Southern Water's response to Arun District Council's consultation on further information in relation to the Environmental Statement on application F/4/20/OUT

Southern Water owns and operates Ford Wastewater Treatment Works (WTW), adjacent to the proposed development area. With reference to paragraph 2.16 of the Environmental Statement Addendum, which states that no response has been received from Southern Water, we confirm that on 27 November 2020 we sent a further response to Hoare Lea's letter dated 5 November 2020. A confirmation of receipt from Hoare Lea on 2 December stated the following:

FIGURE 5. ILLUSTRATIVE MASTERPLAN

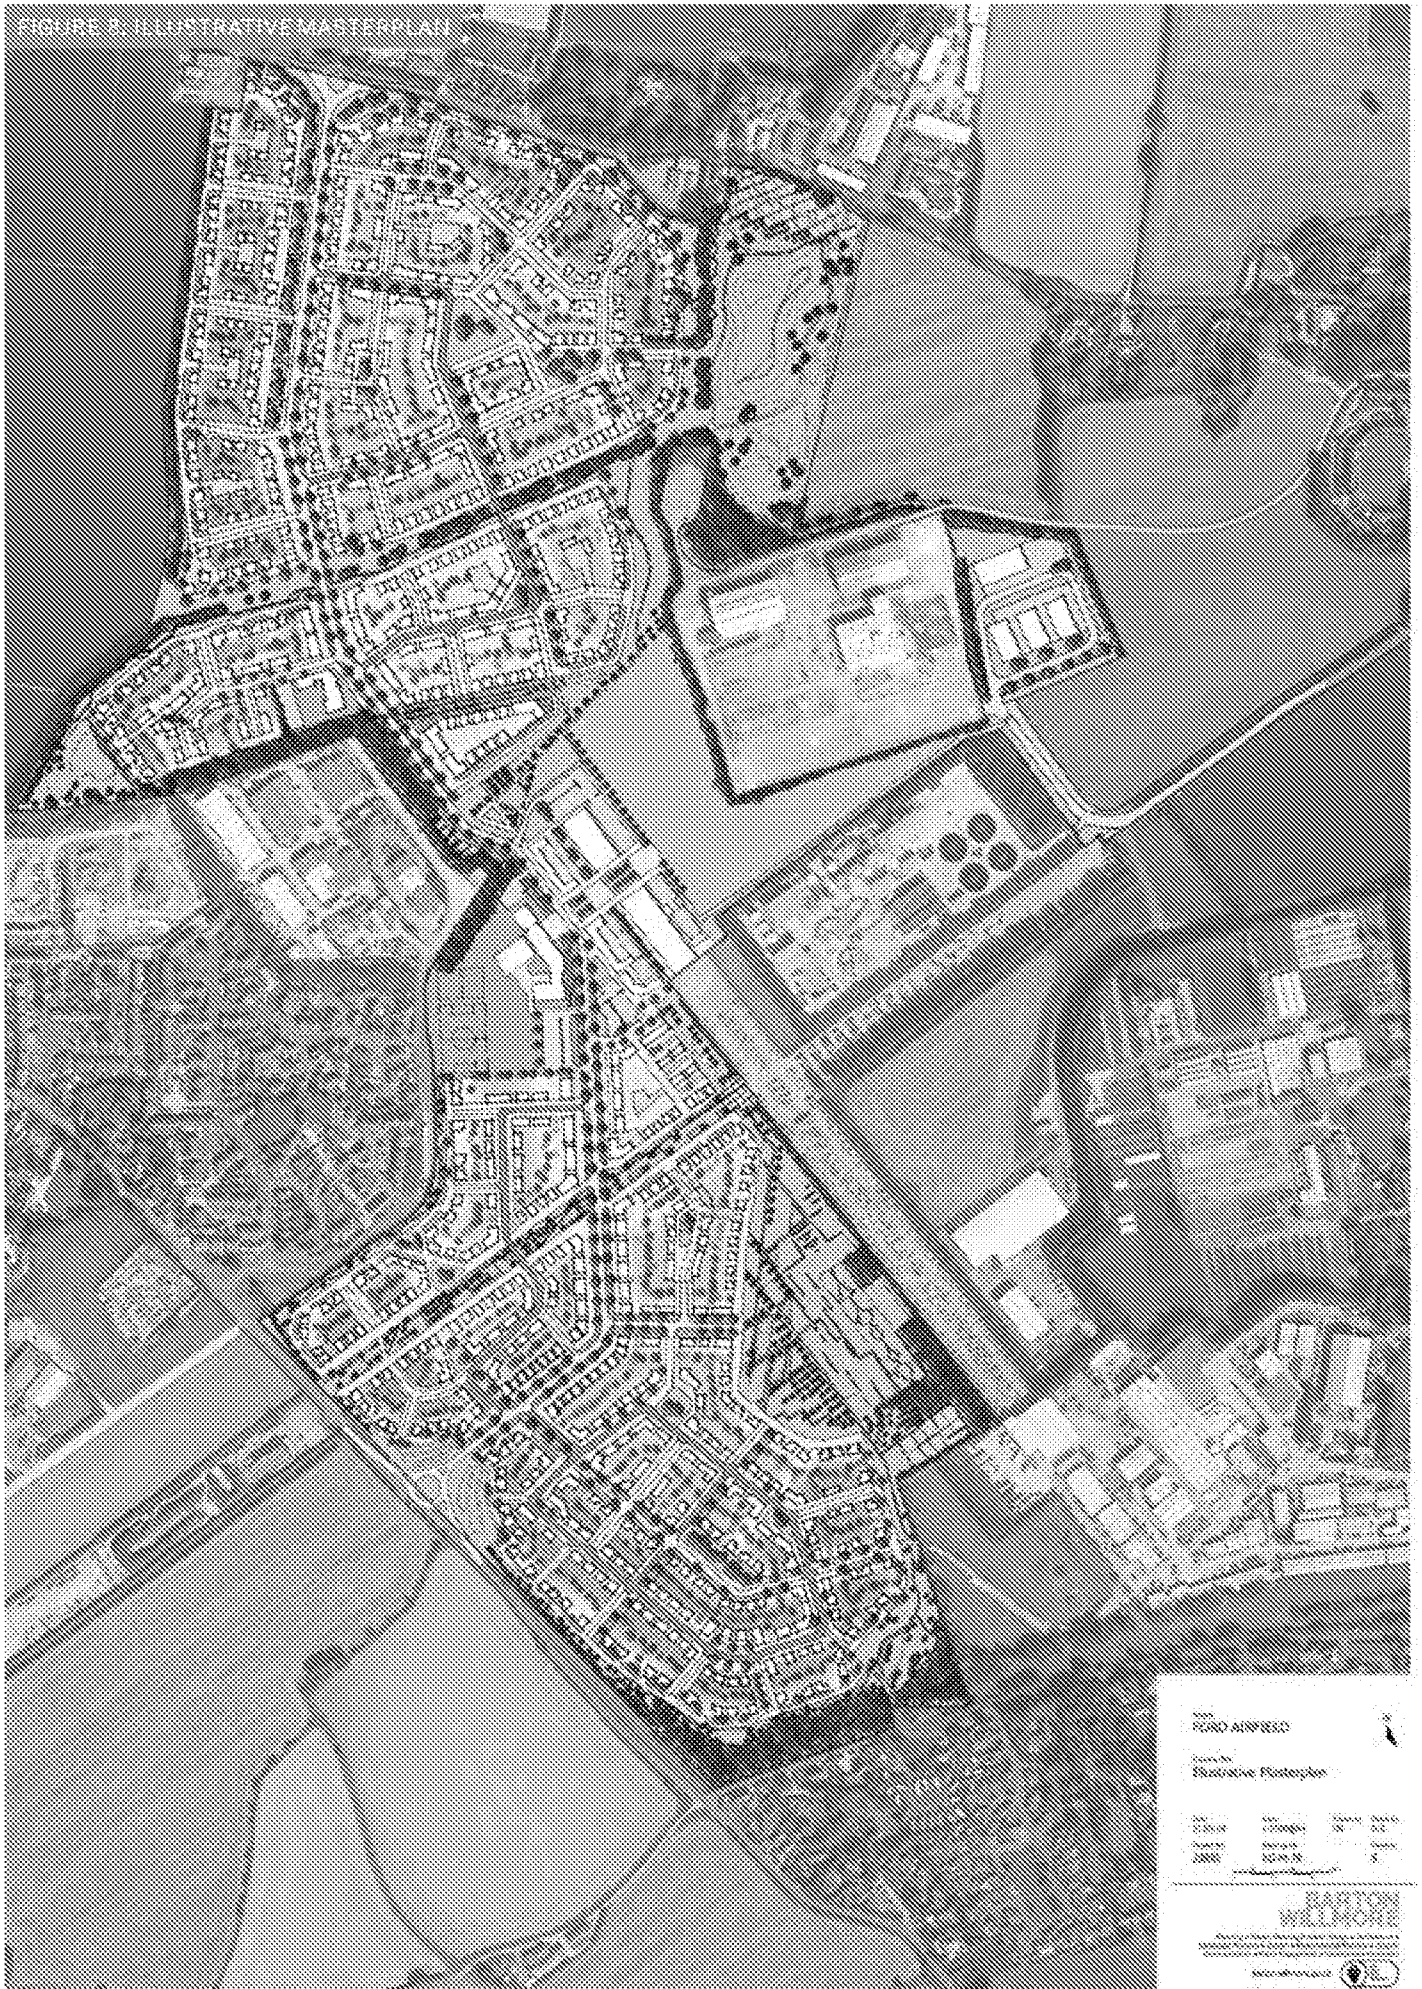
The submitted masterplan uses the odour contours, as presented in the February 2020 odour assessment, to define areas suitable for development. The transposition of data from the odour report to inform that masterplan is acceptable, i.e. the use of Southern Water's suggested odour criterion.

Each of the above-listed items is likely to result in either an increase in the size or shape of the odour contours used to inform the proposed development masterplan layout. As such, the proposed masterplan in its current form may result in placing sensitive receptors in an area where odour impact and complaints may be expected to occur.

As the results are marginal, we recommend that a site survey and revised odour assessment are conducted prior to the approval of the outline planning application, using the more conservative assessment parameters recommended by Southern Water. This will help to ensure a sound and sensible approach is taken to safeguarding Ford WTW's ability to continue to accommodate future growth in Arun district.
